Our Case Number: ABP-316119-23

Re: DART+ South West Electrified Heavy Railway Order - Hazelhatch & Celbridge Station to Heuston Station, and Hesuton Station to Glasnevin
County Dublin and County Kildare

Re: Case Number ABP - 316119- 23

Dart + South West Electrified Heavy Rail Order- Hazelhatch & Celbridge Station to Heuston Station and Heuston Station to Glasnevin, Co Dublin and Co Kildare.

Figure 5-136 Zones D-2 & D-3: PPTBL & Glasnevin Cemetery Bridge Compound Haul Routes

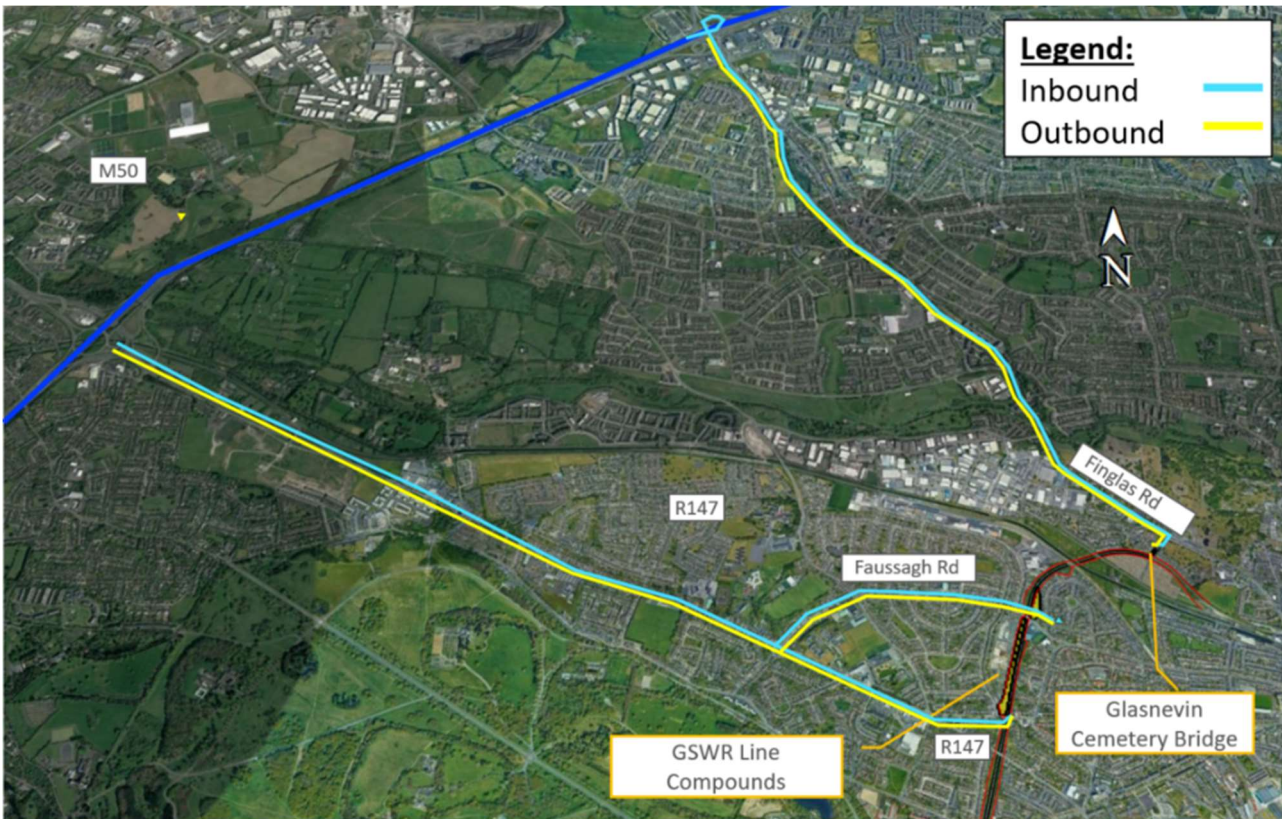
Are these spaces in additions to C 5 space for hearse and funeral? This is too open-ended and does not give any comfort and DCT need to review the location for an alternative temporary parking location. Can an alternative location be sought for the construction compound, with large areas of green space available immediately outside the car park.

See also comments above in relation to the inadequate size of the car park and location for arrival of a hearse and mourners cars.
